Final Plat of  
**MAYBERRY, COLORADO SPRINGS FILING NO. 4**  
 Being a replat of Tract A, MAYBERRY, COLORADO SPRINGS FILING NO. 3  
 Lying the Northeast Quarter of Section 14, Township 14 South, Range 63 West of the 6th Principal Meridian  
 County of El Paso (Unincorporated), State of Colorado

Sheet 2 of 3

Final Plat of  
**MAYBERRY, COLORADO SPRINGS FILING NO. 4**  
 Being a replat of Tract A, MAYBERRY, COLORADO SPRINGS FILING NO. 3  
 Lying the Northeast Quarter of Section 14, Township 14 South, Range 63 West of the 6th Principal Meridian  
 County of El Paso (Unincorporated), State of Colorado  
**AS HEREBY REPLATTED**

Sheet 3 of 3

Final Plat of
MAYBERRY, COLORADO SPRINGS FILING NO. 4
 Being a replat of Tract A, MAYBERRY, COLORADO SPRINGS FILING NO. 3
 Lying the Northeast Quarter of Section 14, Township 14 South, Range 63 West of the 6th Principal Meridian
 County of El Paso (Unincorporated), State of Colorado

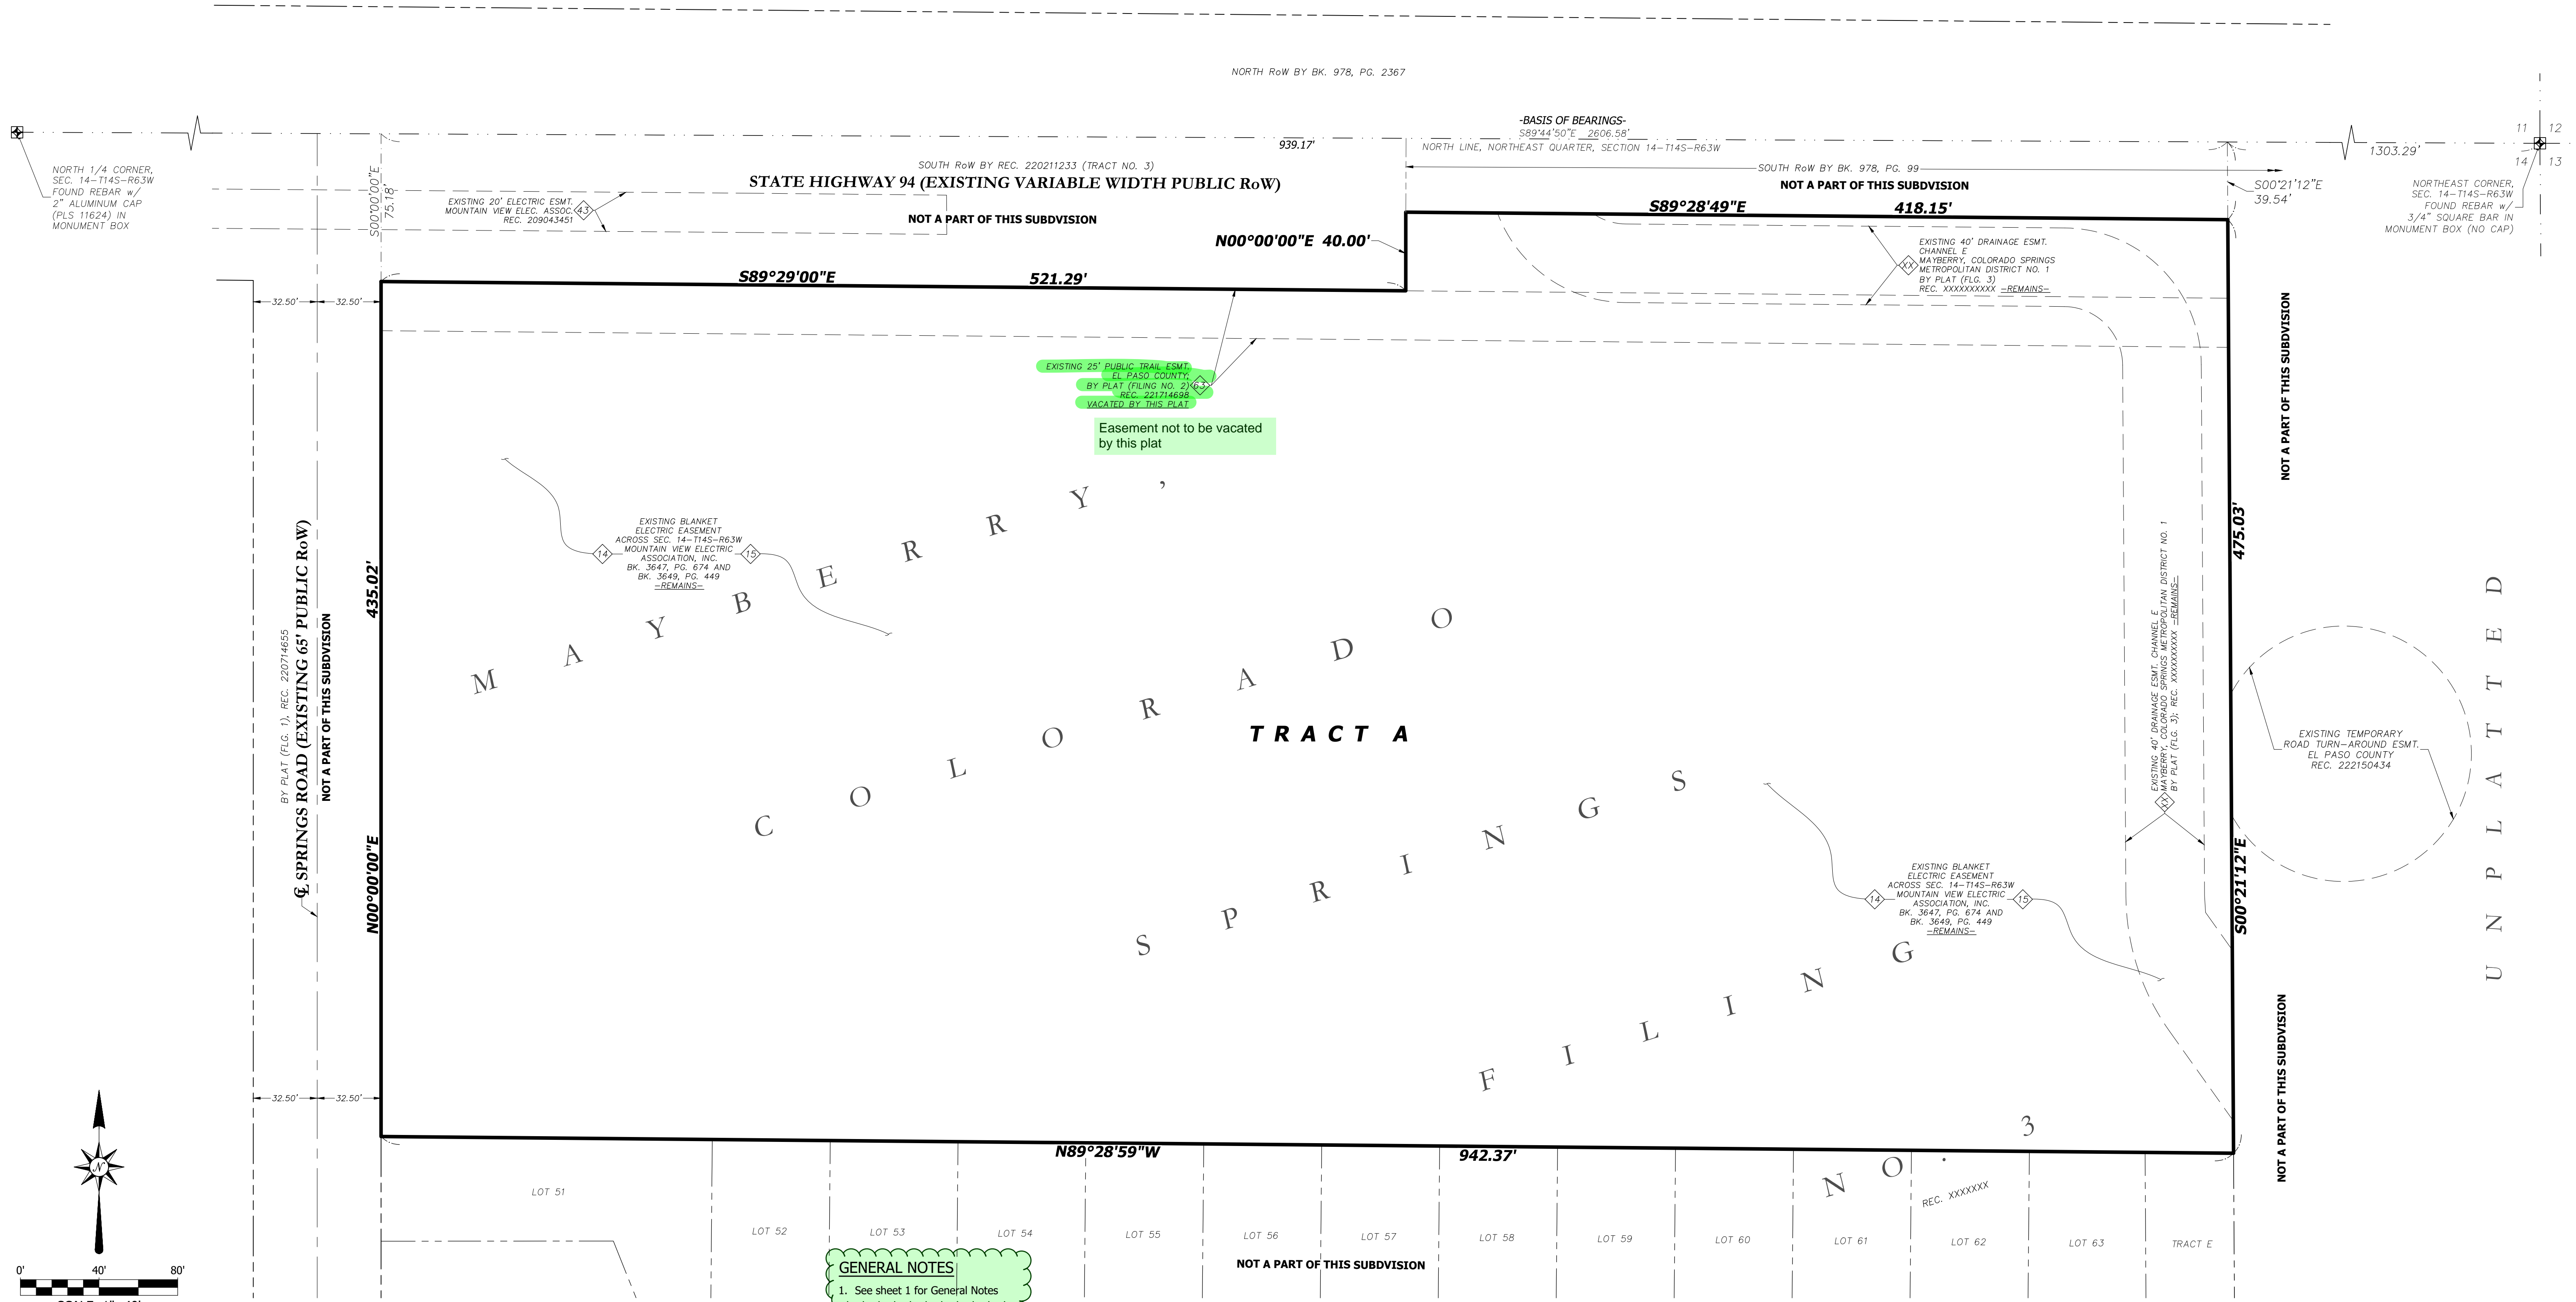
Provide a plat note that indicates that no improvements in the easement area that would unreasonably interfere with El Paso County's use of the easement area shall be allowed without prior County approval. No trees, shrubs, or plantings that will impair the structural integrity of the public storm sewer within the easement shall be planted or allowed to grow in this area.
